16 March 2026

FLOODING PEER REVIEW FOR STATE SIGNIFICANT DEVELOPMENT APPLICATION (SSDA) AT 4-6 POPES ROAD, WOONONA (SSD-73910208), IN RESPECT OF DEPARTMENT OF PLANNING, HOUSING AND INFRASTRUCTURE RFI DATED 25 FEBRUARY 2026

Table 1 MA peer review of DPHI comments and ACOR responses.

FIGURE F50

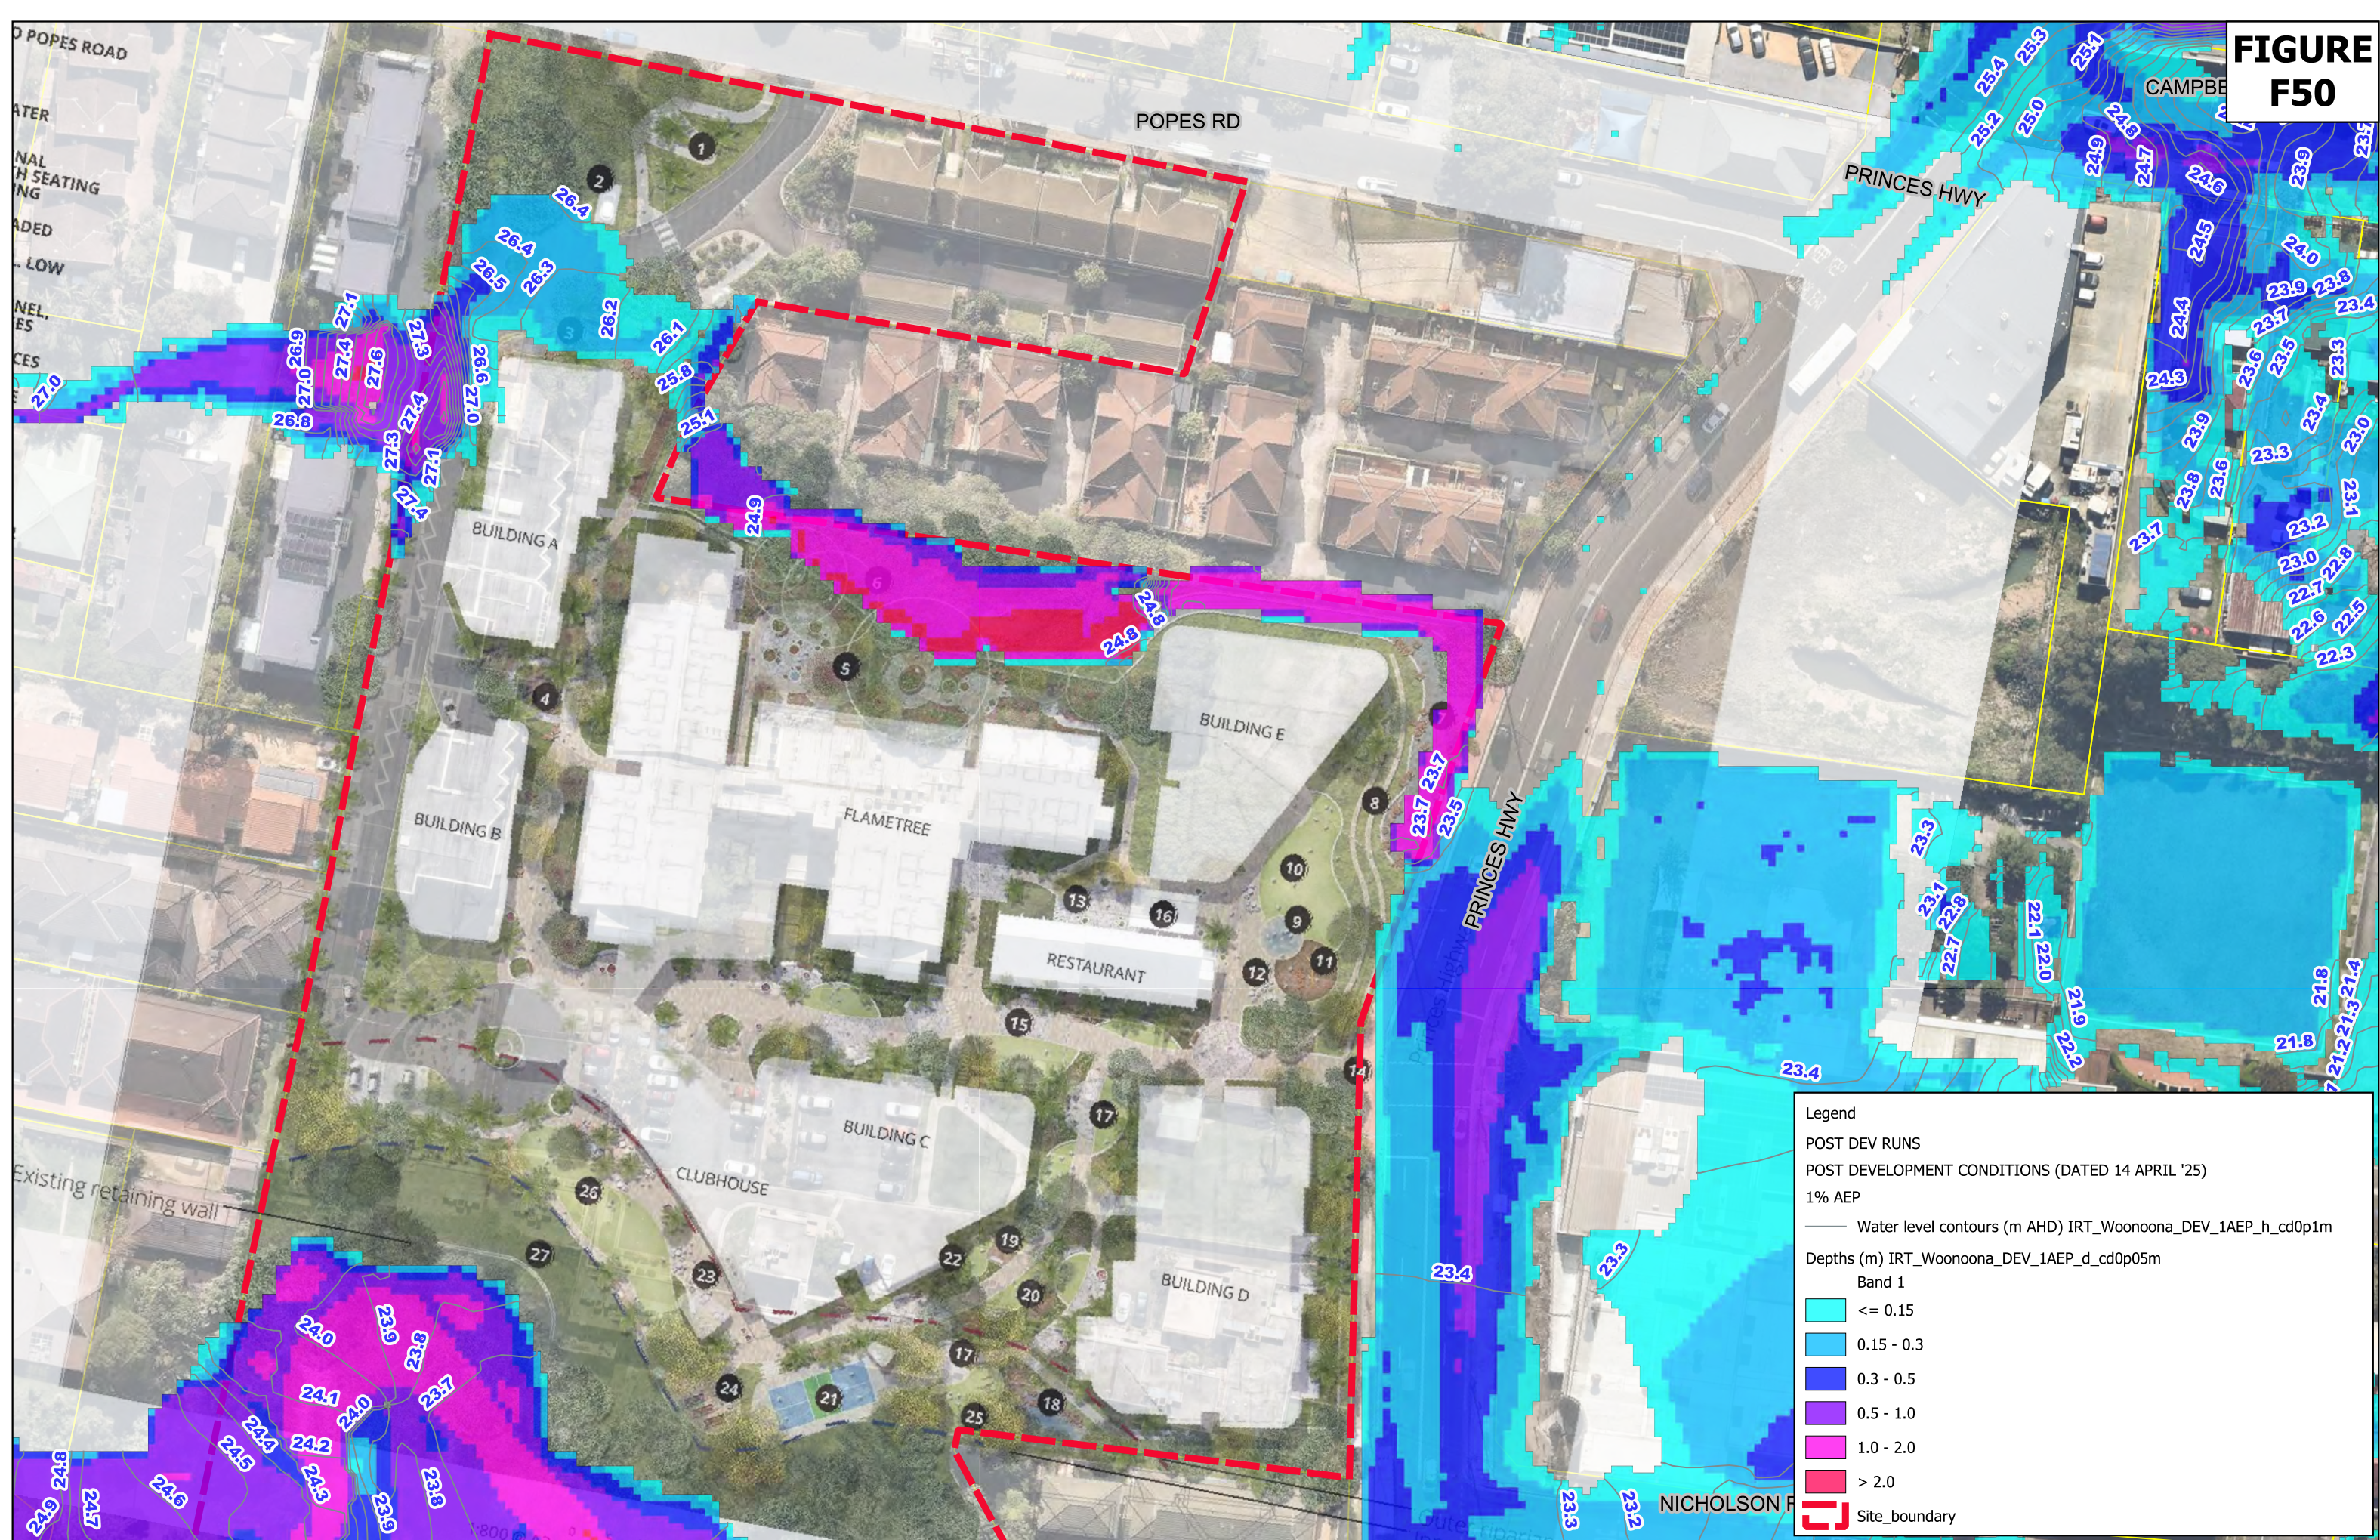
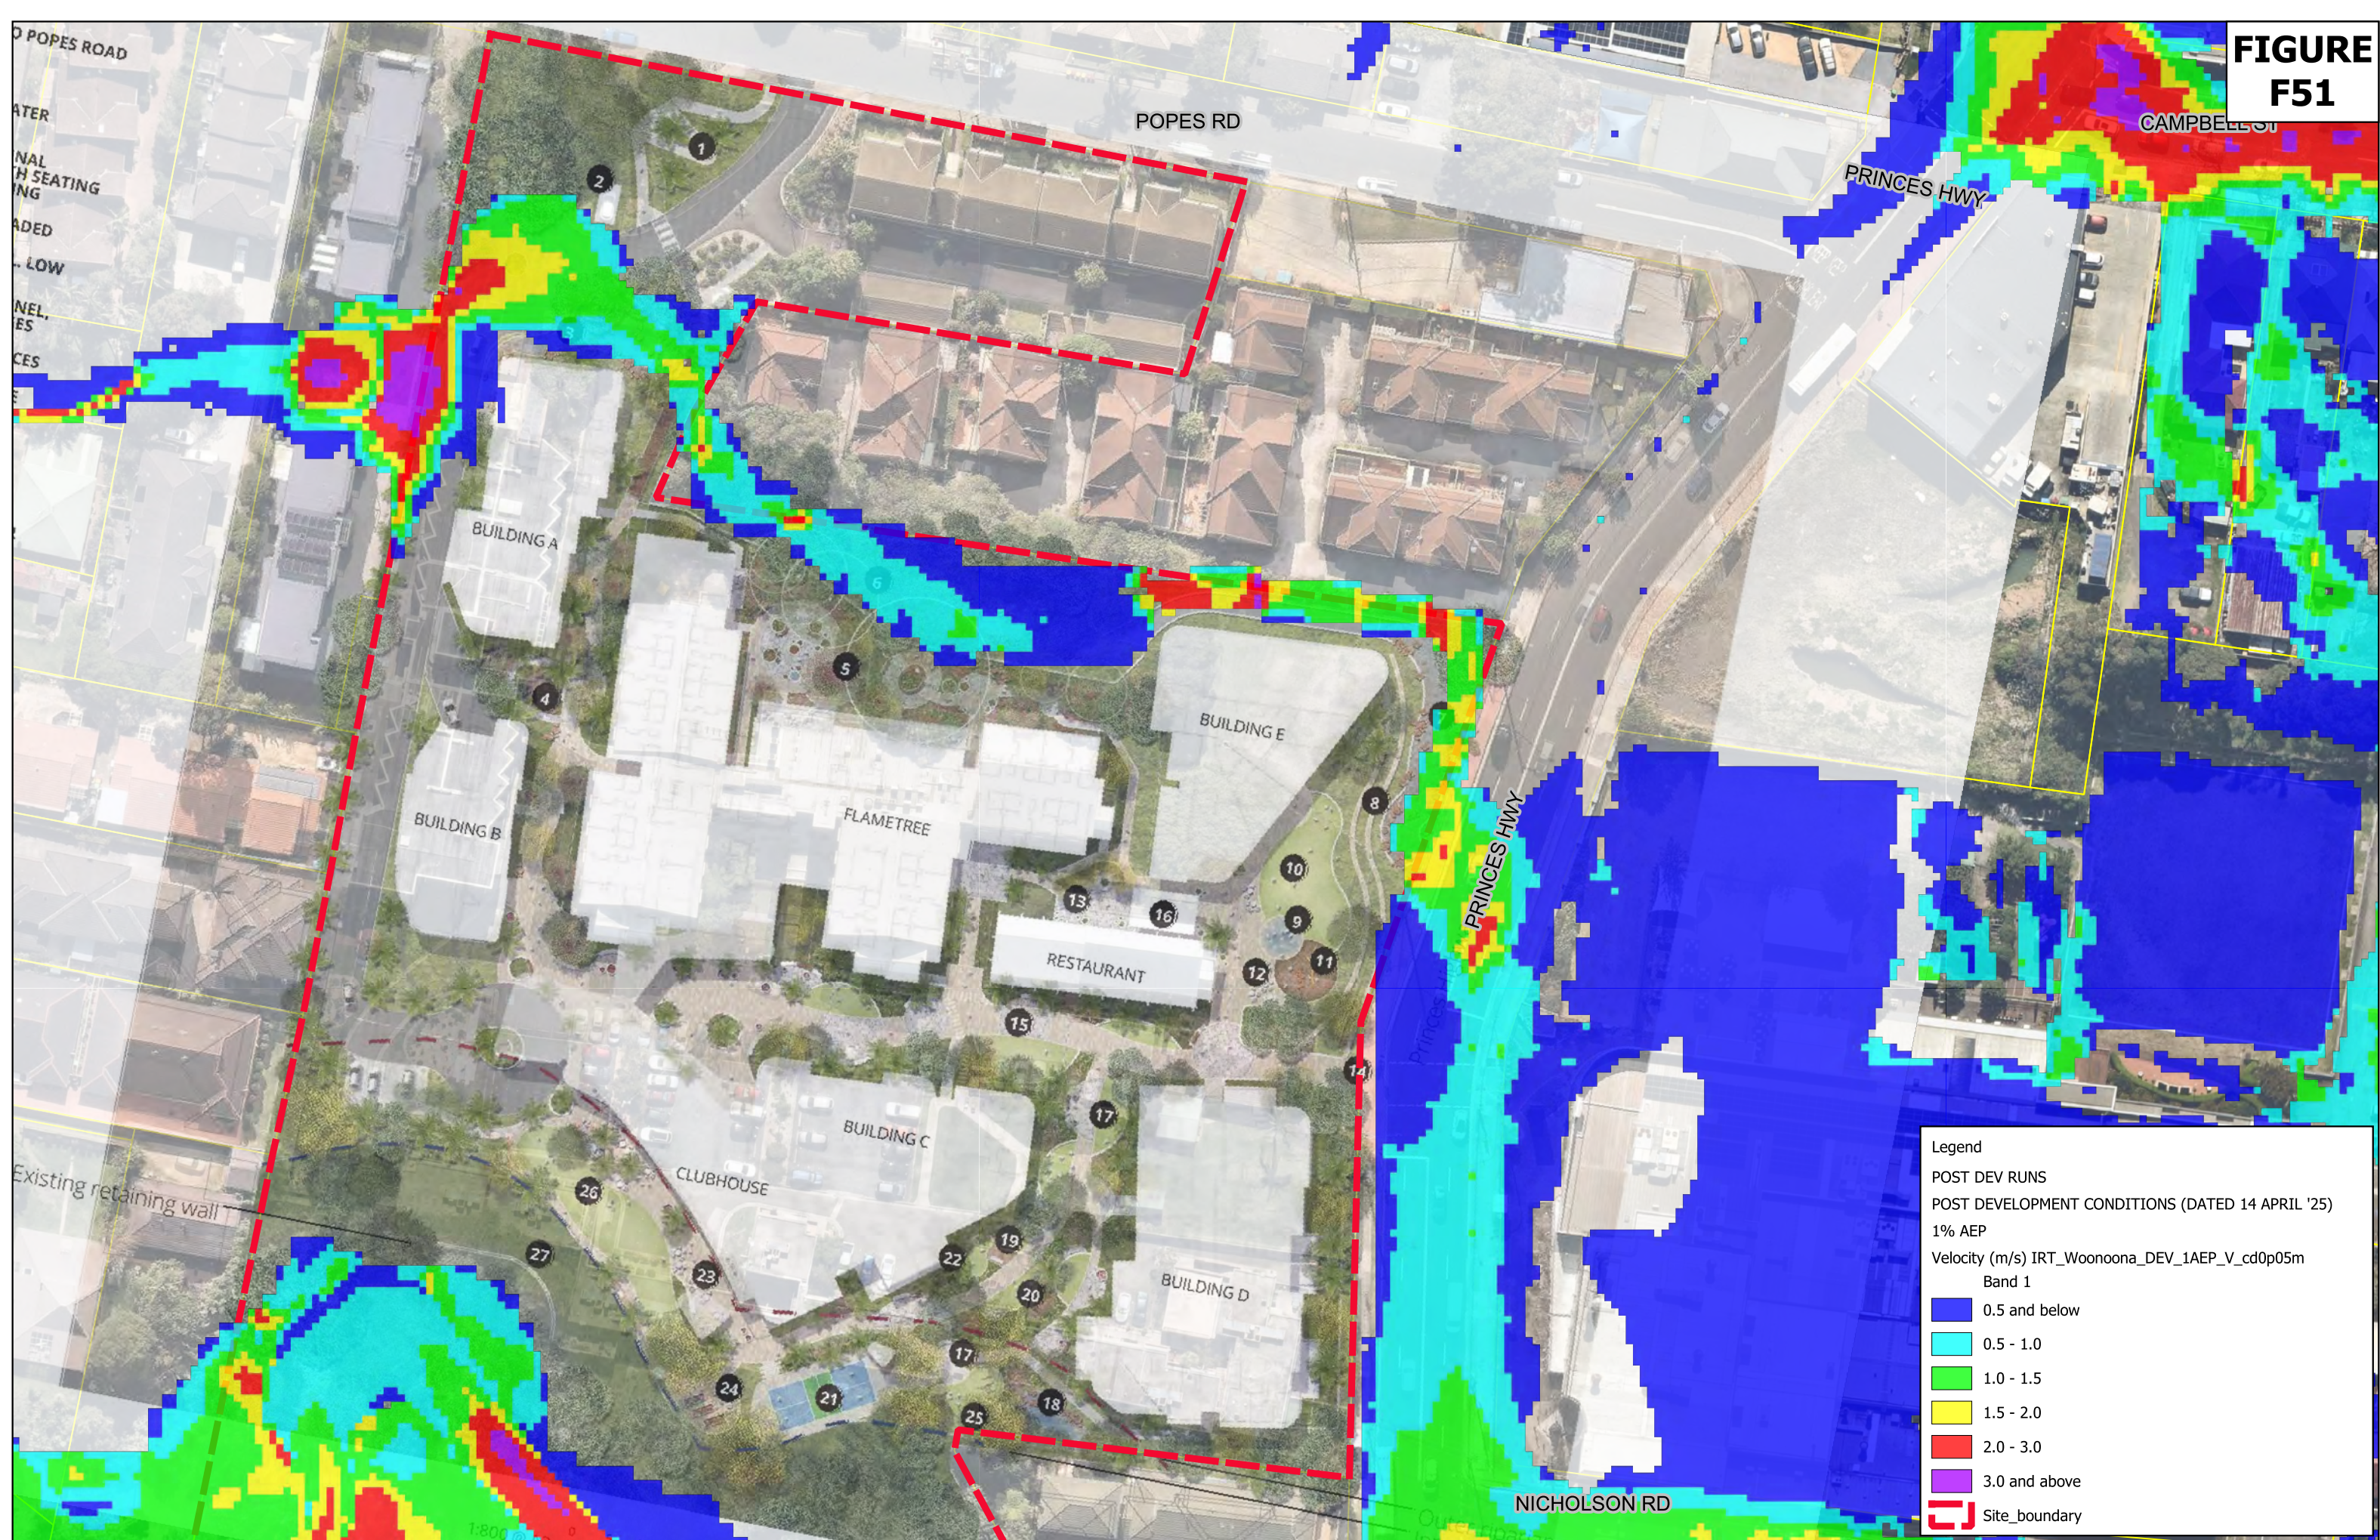
a. the 1% AEP post development map (Figures 50 to 52) extent is to be updated to show the entire site	a. The 1% AEP post development map (Figures 50 to 52) have been updated to include the entire site. See attached.	No further comment.
